DECISION DELEGATED TO HEAD OF PLANNING

Application No:	H09-0443-26	Applicant:	Mr R Philips
Proposal:	Proposed Change of Use of Agricultural Building to Dwelling		
Location:	Fur Cottage Further Old Gate Holbeach		
Terminal Date:	6th July 2026

Schedule 2, Part 3, Class Q - Conversion vs Rebuild

NORTH ELEVATION 1:100

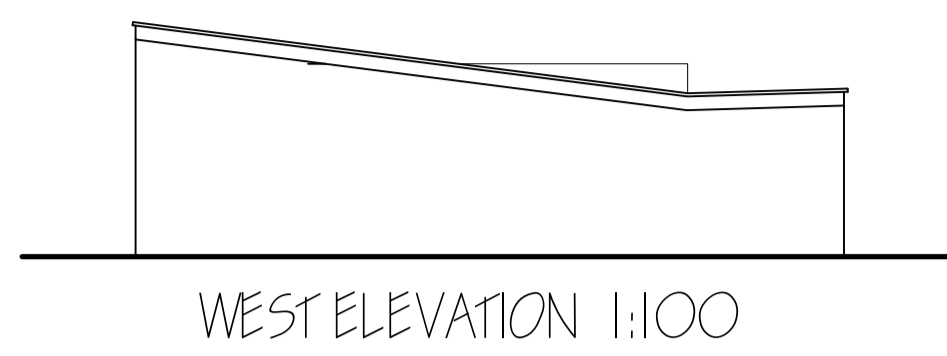
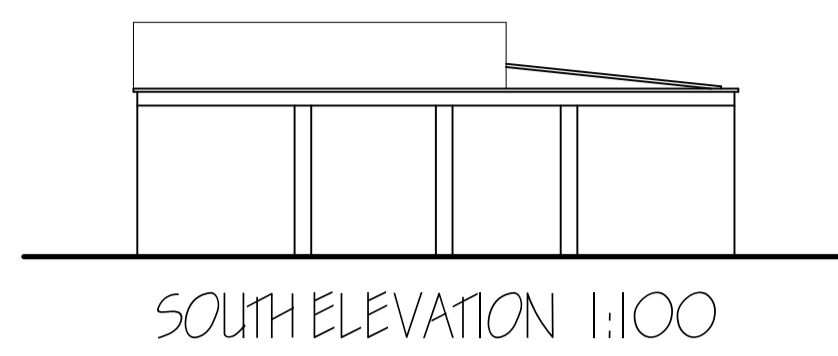
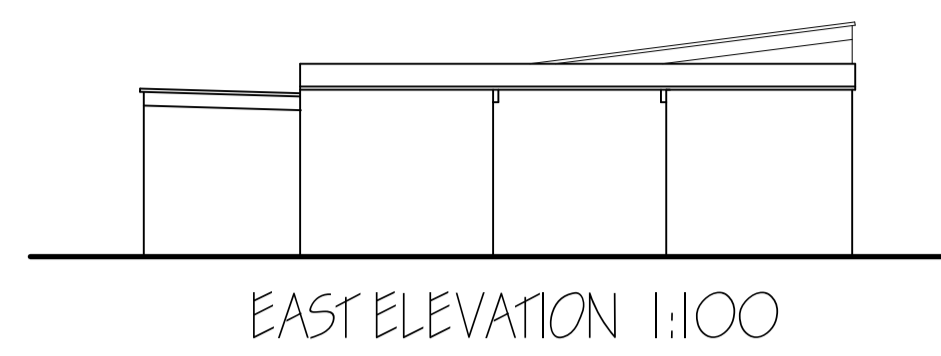
In this case it is important to note that no structural survey has been provided. The existing structure appears to be somewhat dilapidated and comprises a form that appears to be lacking structural soundness, in that the building has areas of openness, is of a structure and material finish that lacks a likelihood of supporting a residential conversion, and appears visually unsuitable for direct conversion.

The use of the building as a dwellinghouse would require notable and, in the Local Planning Authority's opinion, excessive work, including the infilling of open areas along various elevations and would most likely require extensive work throughout in order to be suitable for a conversion to a dwellinghouse.

GROUND FLOOR PLAN PLAN 1:50

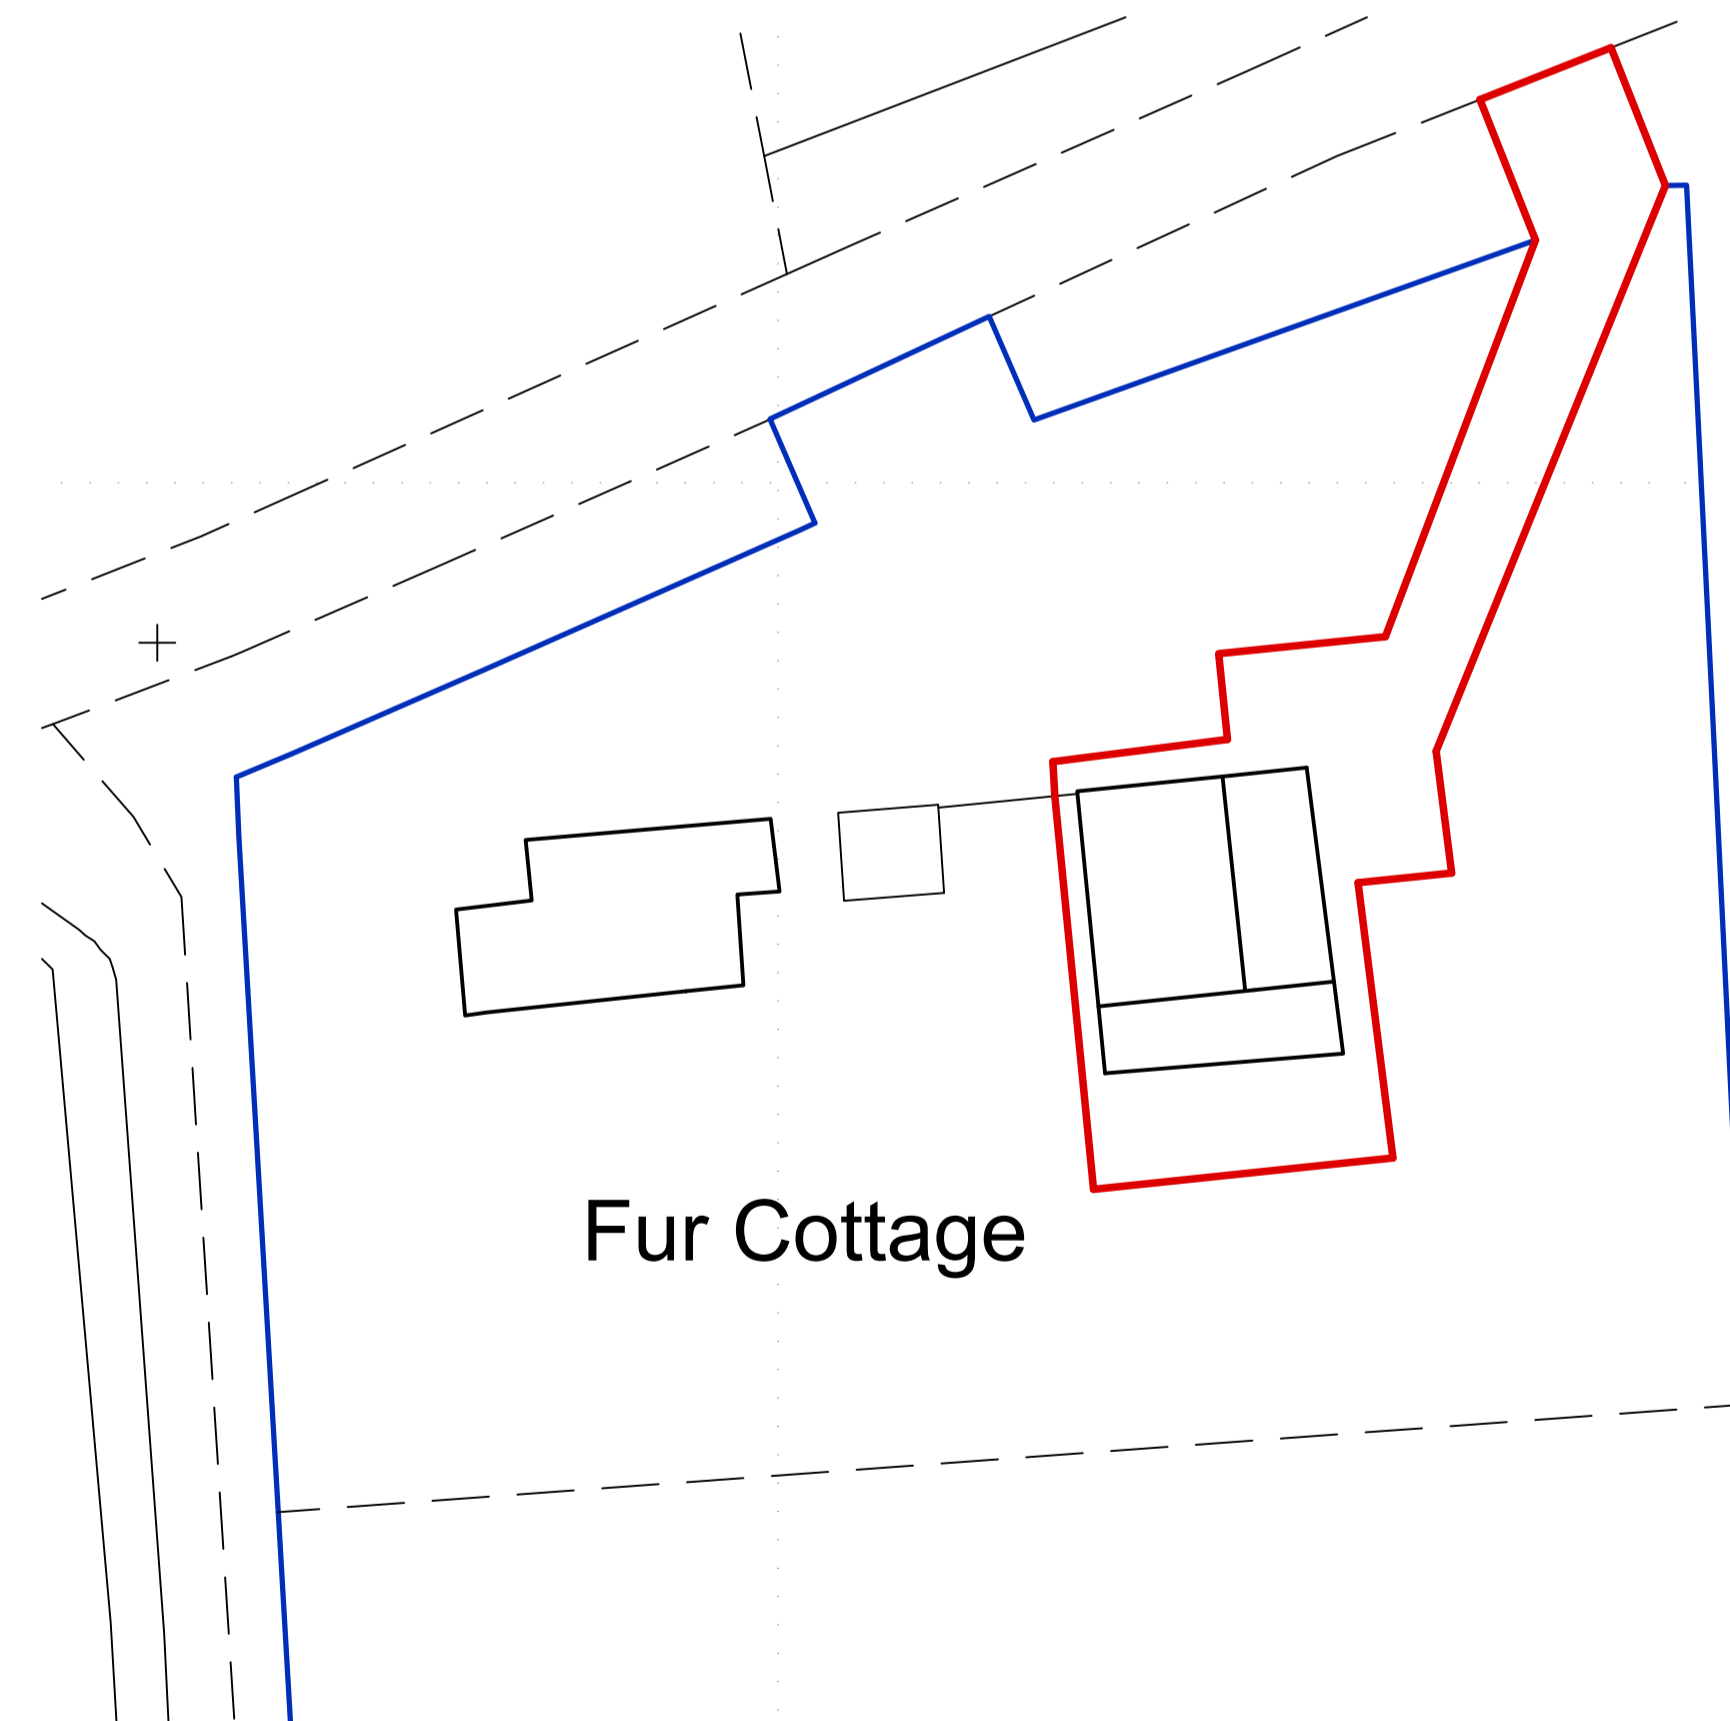
Whilst the individual minimum bedroom sizes accord with the requirements of Nationally Described Space Standards, the submitted proposal comprises a gross internal floor area that would be notably below 50sqm in total.

The proposed dwelling, as assessed above, comprises two bedrooms (three persons) and the submitted floor plans indicate that the proposed gross internal floor area comprises less than 50sqm. The nationally described space standards require that a single storey, two bedroom dwelling must have a minimum gross internal floor area of 61sqm and therefore, the proposal fails to conform to the requirements of the nationally described space standards.

Additionally, the proposed dwellinghouse would comprise a gross internal floor area of less than 50sqm. As such, the proposed internal area falls notably under that outlined within the nationally described space standards for a single storey dwelling comprising two bedrooms (three persons), to
